M3 Junction 9 Improvement

Scheme Number: TR010055

8.22 Applicant Response to the Examining Authority's Third Written Questions (ExQ3)

27 October 2023

Scale	1:500	Designed	GP	Drawn	GP	Checked	LC	Approved	MF
Original Size	A1	Date	22.09.23	Date	22.09.23	Date	22.09.23	Date	22.09.23

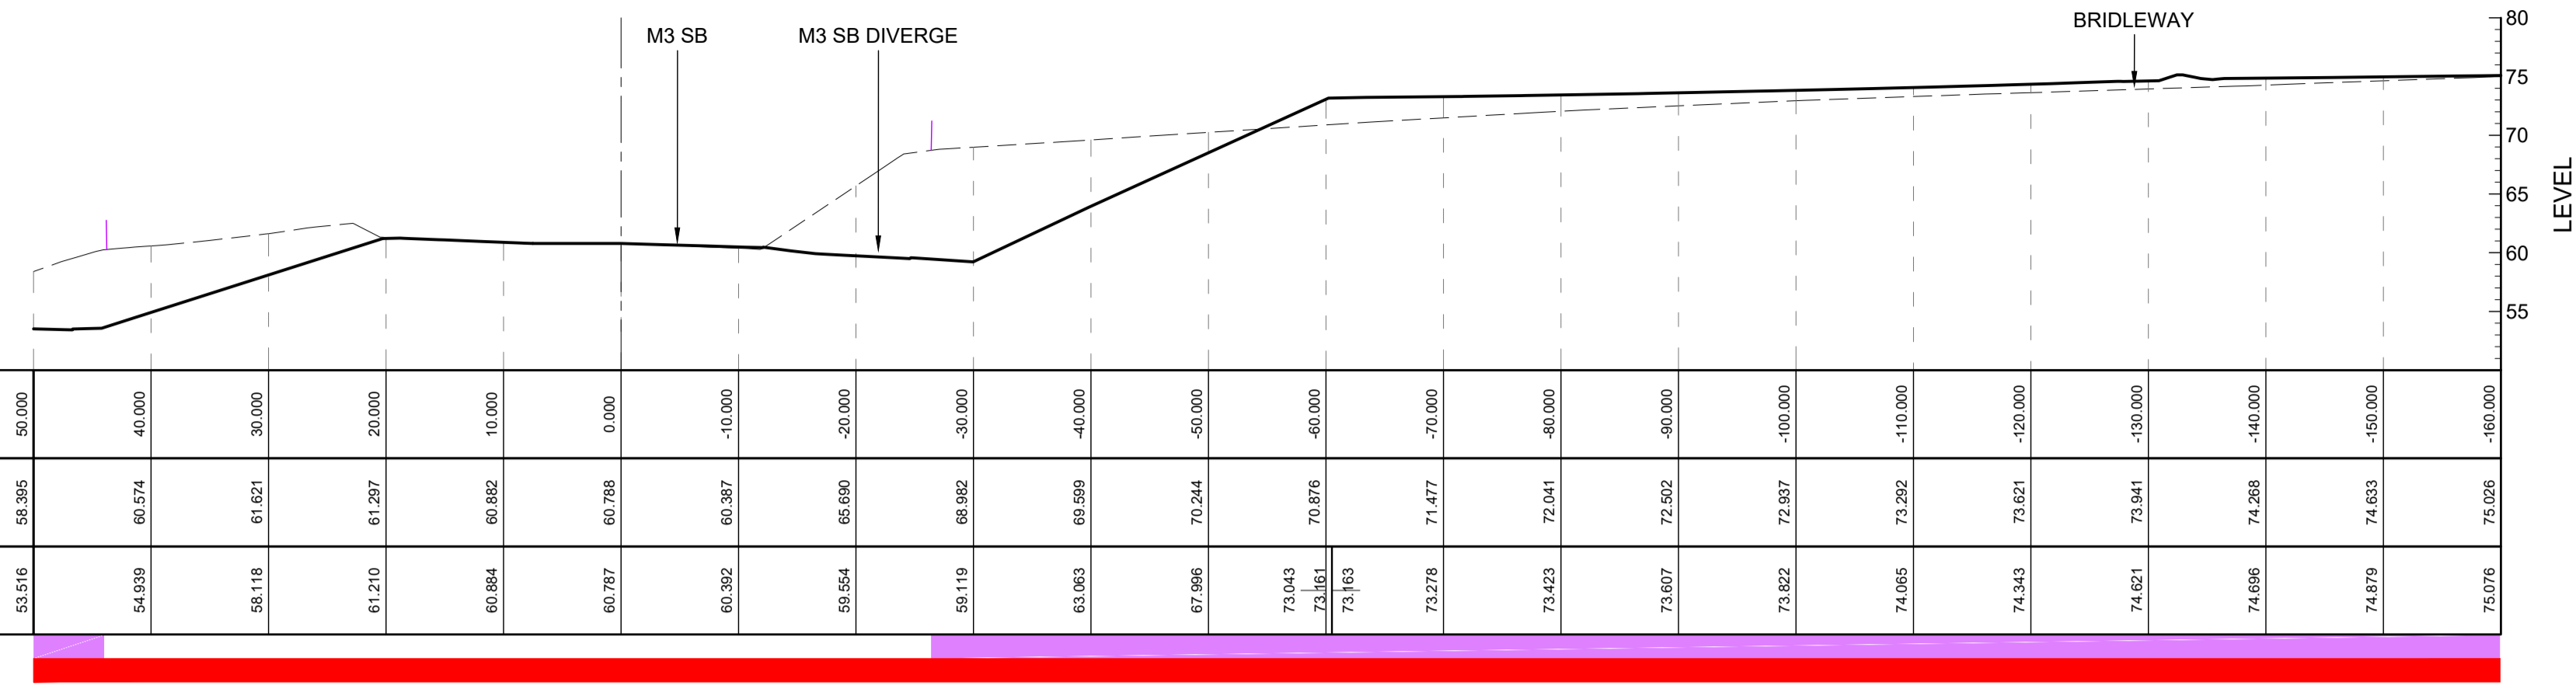
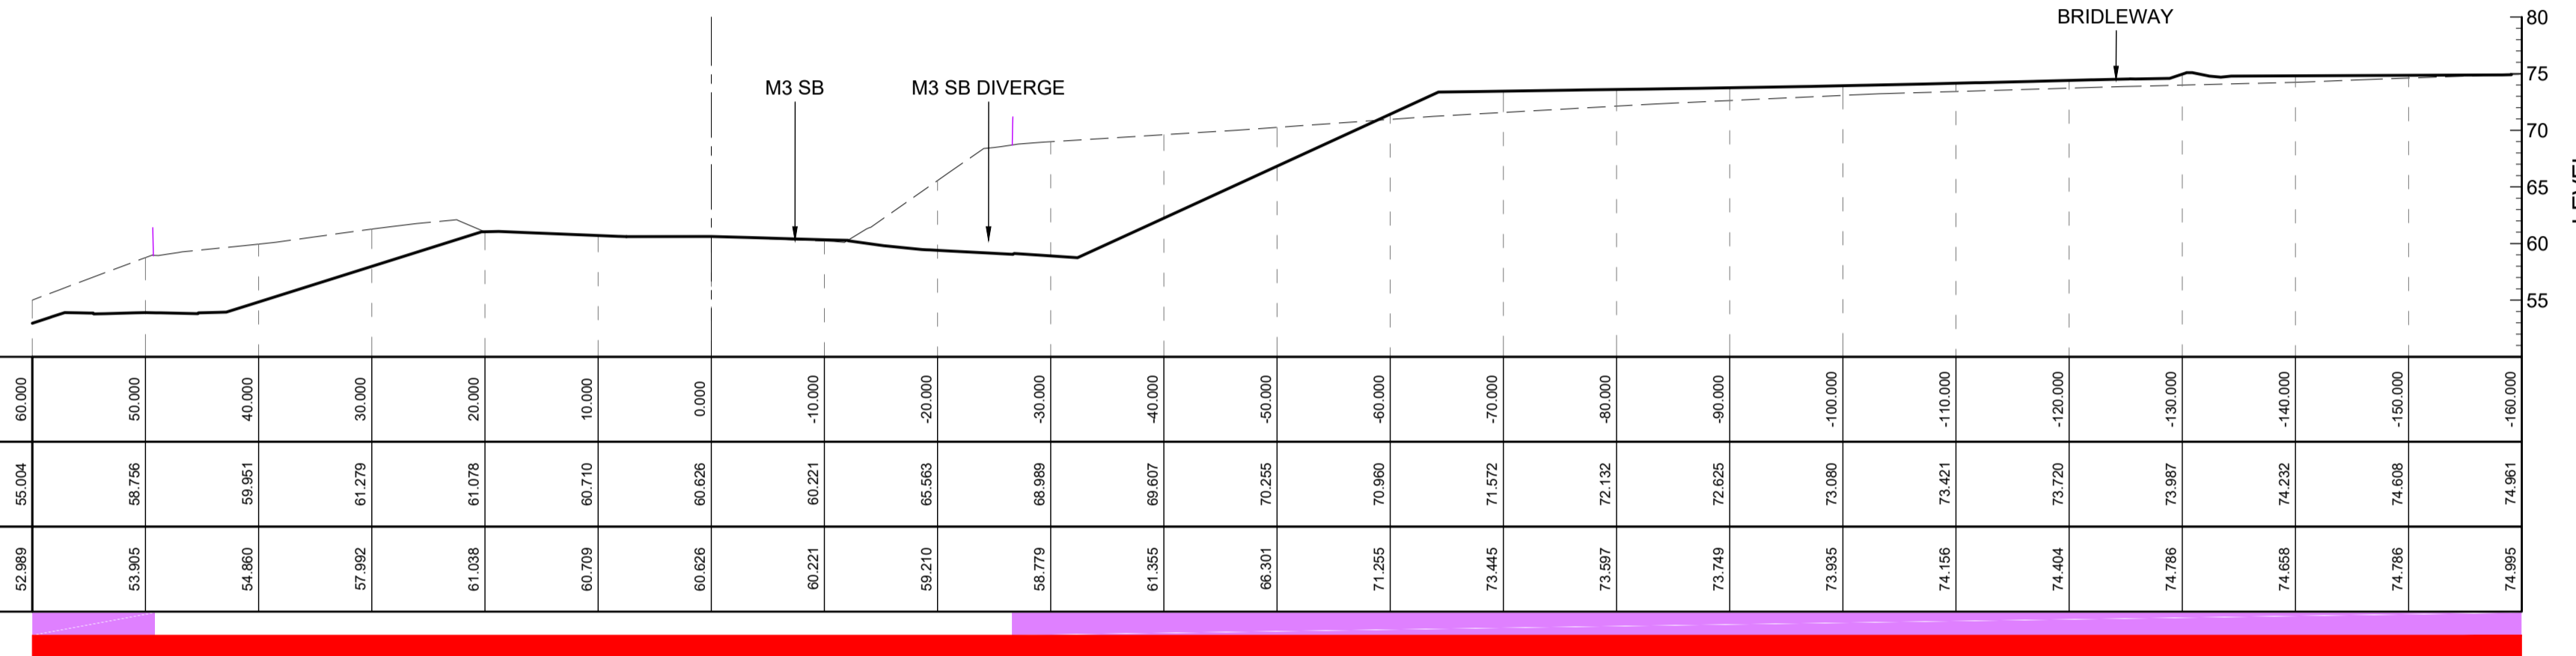
ExQ3	Question to:	Question
Q1.3.1	General The Applicant	In ExQ 1.2.3 [PD-011] the ExA requested detailed engineering cross sections at 20m intervals along string CH-HML-E_M3SB between chainages 3000 and 4300. The cross sections were provided by the Applicant [REP5-003] however they omitted distance and level data as would be anticipated in detailed engineering sections. Please provide an update to the cross sections submitted at deadline 5 to include distance and level data in rows below the drawn sections.
Applicant Response		
Please refer to Engineering Sections at 20m Intervals - ExA WQ2 1.2.3 (2.15, Rev 1) submitted at Deadline 6.
